Letter No. **A1/25050/2003**

Sub: CMDA - **Planning Permission - Construction of Ground Floor and First Floor (part) Residential Building with 2 dwelling units at Plot No.1398, Lakshmi Nagar Extension in S.No.148(part) of Porur Village - Development Charges and Other Charges to be remitted - Regarding.**

PLAN OF COMPOUND WALL WITH GATE

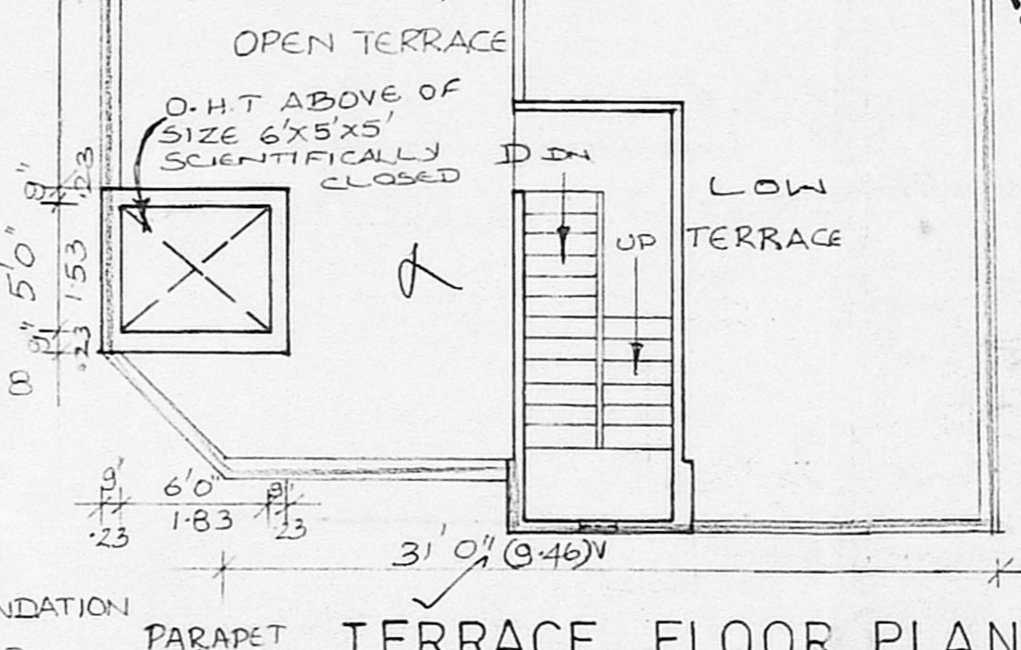
- a) Rain water conservation regulations stipulated by CMDA should be adhered to strictly.
- b) Five copies of Revised plan rectifying the following defects:**
- i) Compound wall height has to be residential to 1.50m instead of 1.80m shown.**
- ii) Location of gate in site plan not shown.**
- iii) Terrace plan for First Floor and Terrace Floor has to be rectified to suit the Ground floor plan and the entire portion shall be indicated.**
